From: David Senus <dsenus@woodardcurran.com>
To: Jean Fraser <JF@portlandmaine.gov>
Date: 9/5/2014 5:09 PM
Subject: RE: 2282 Congress Street- Portland ME re MDEP review

They changed the system type back to just a soil filter (instead of a focal point system), which is okay (that is what they proposed back in July). No concerns on my end. It's disappointing that DEP pushed them in that direction, as I believe the focal point provides better treatment. It's just not formally approved by the Department yet in that configuration.

SHEET TITLE: AMENDED GRADING AND DRAINAGE PLAN

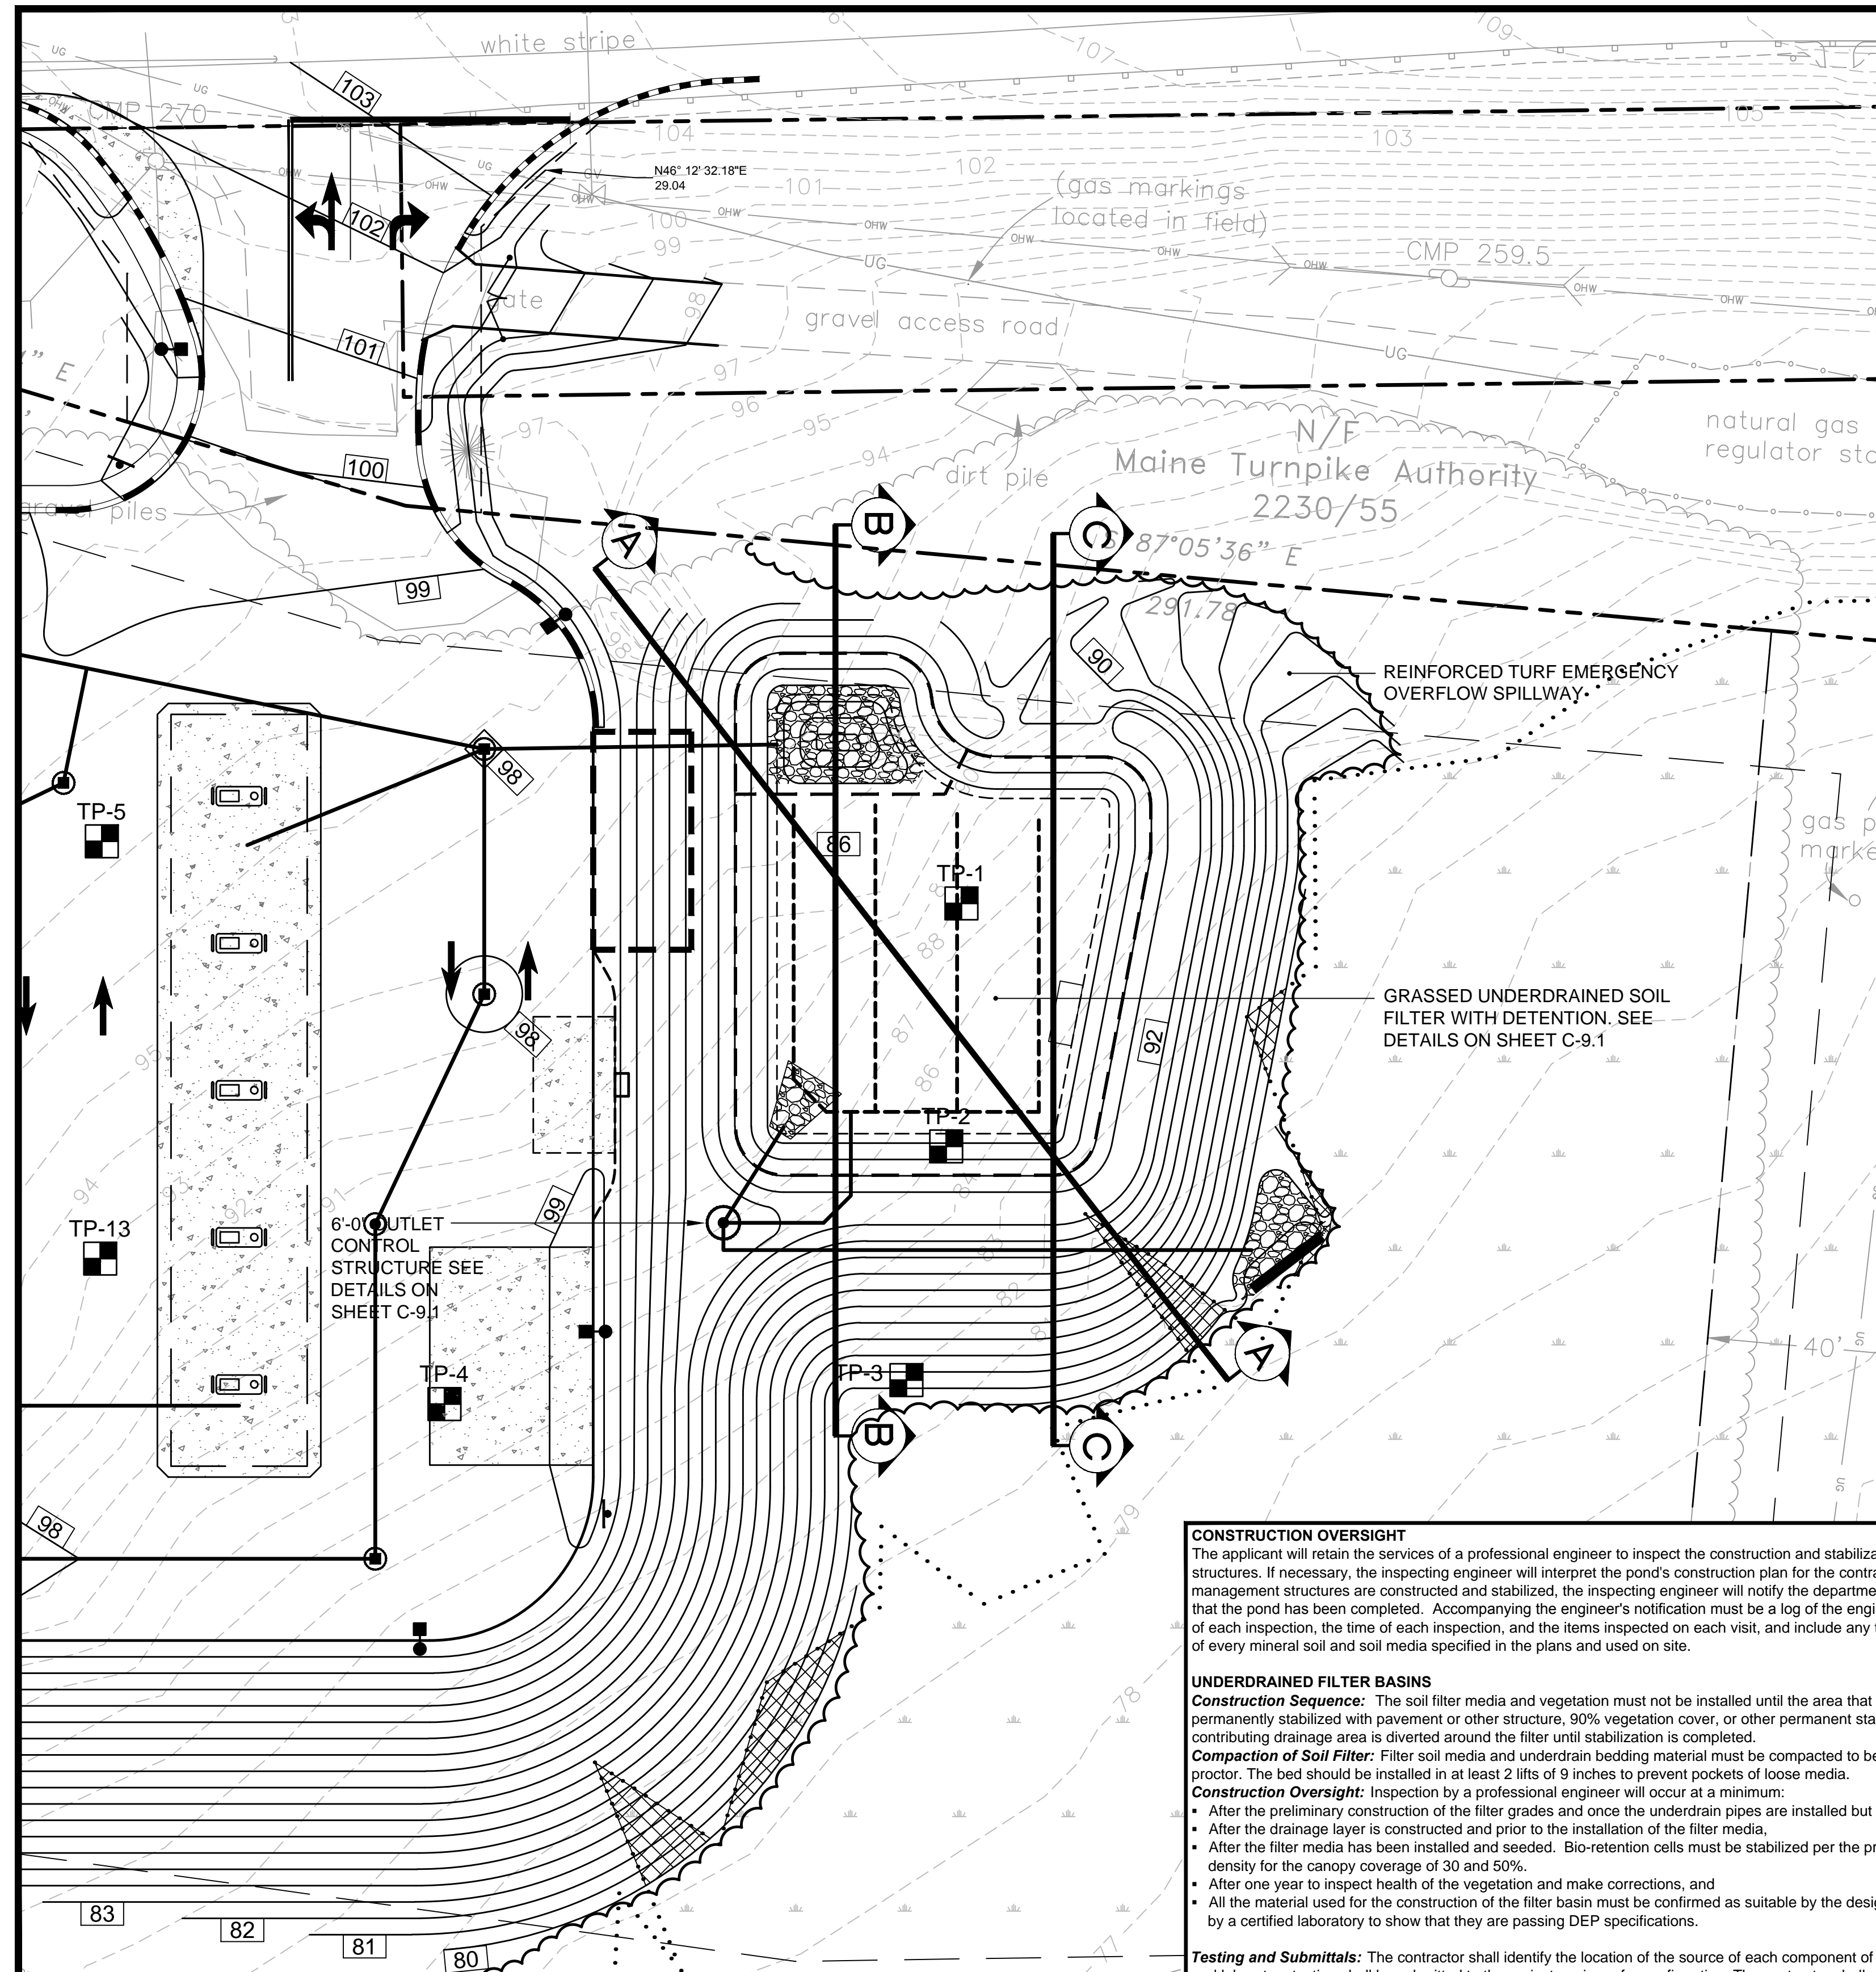
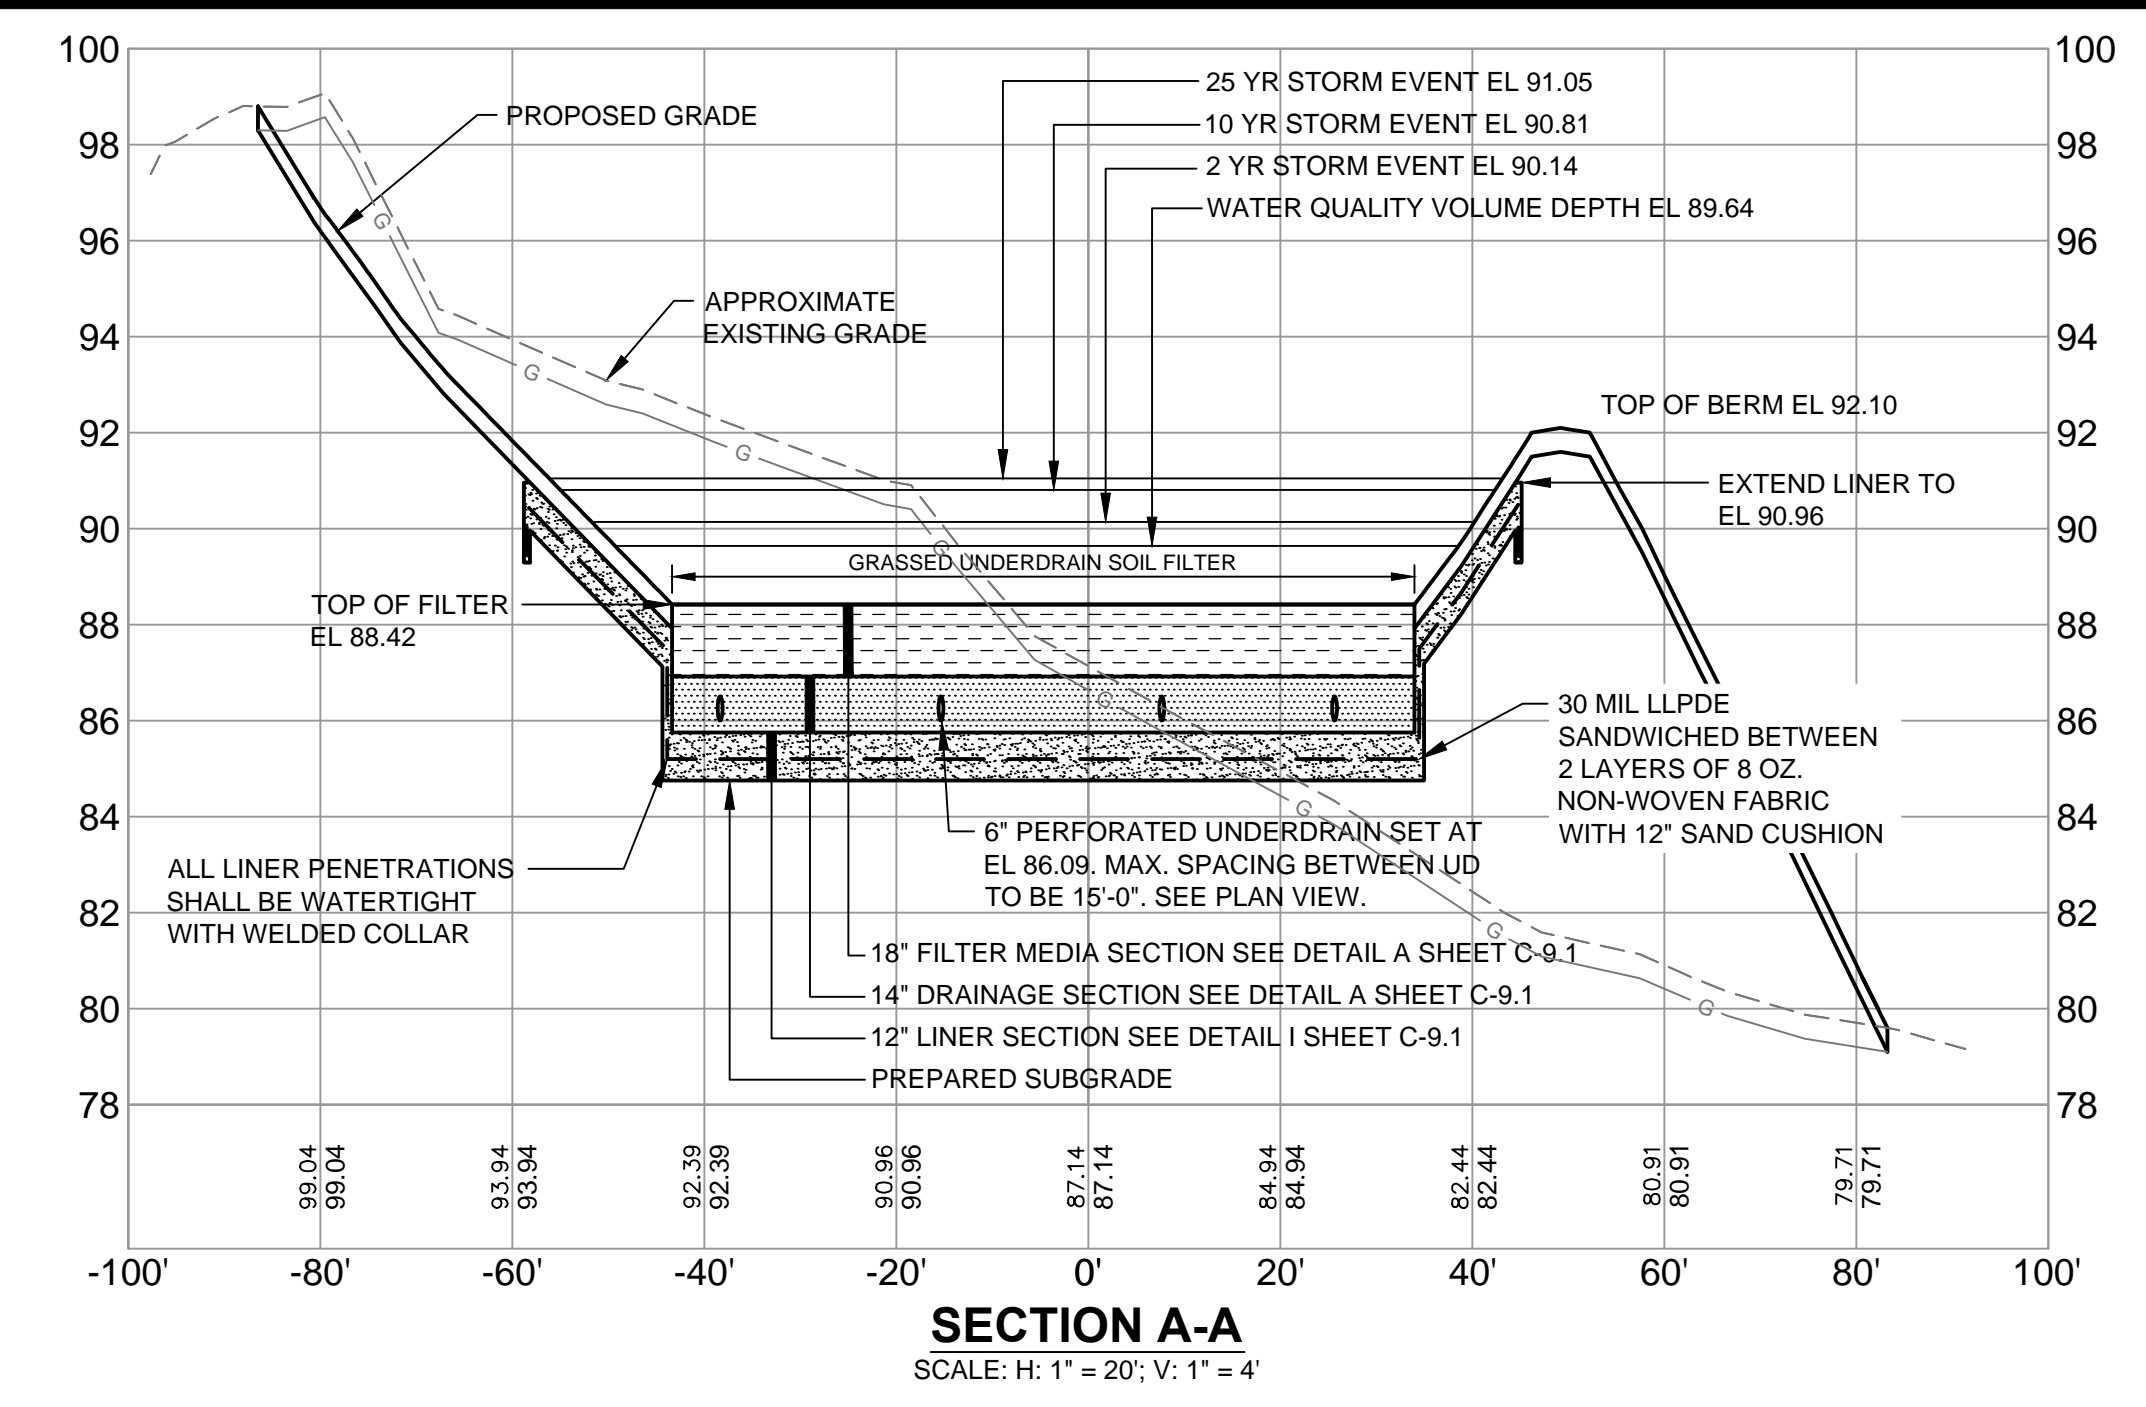
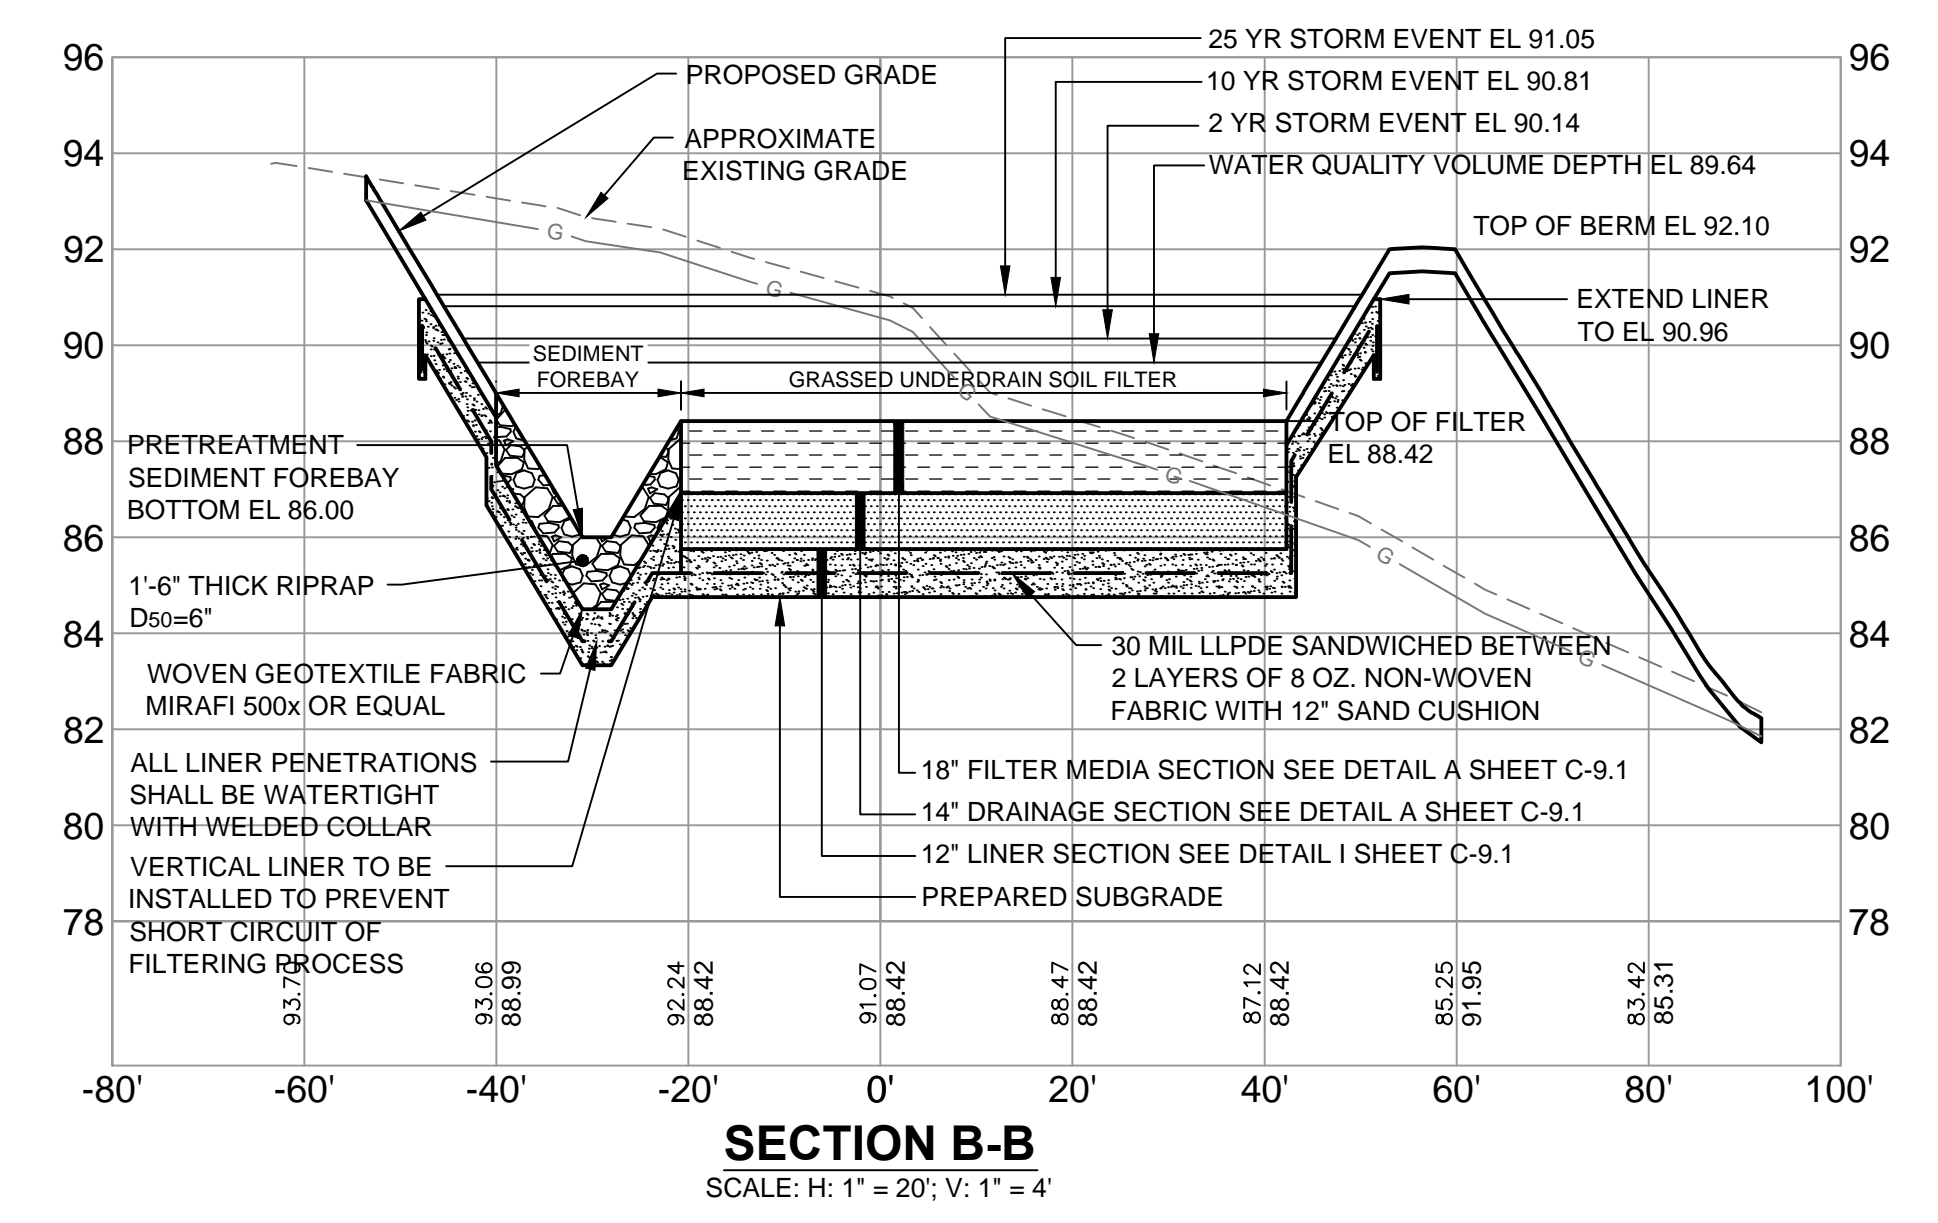
They can plant in the upper areas above the basin. That shouldn't need review by DEP.
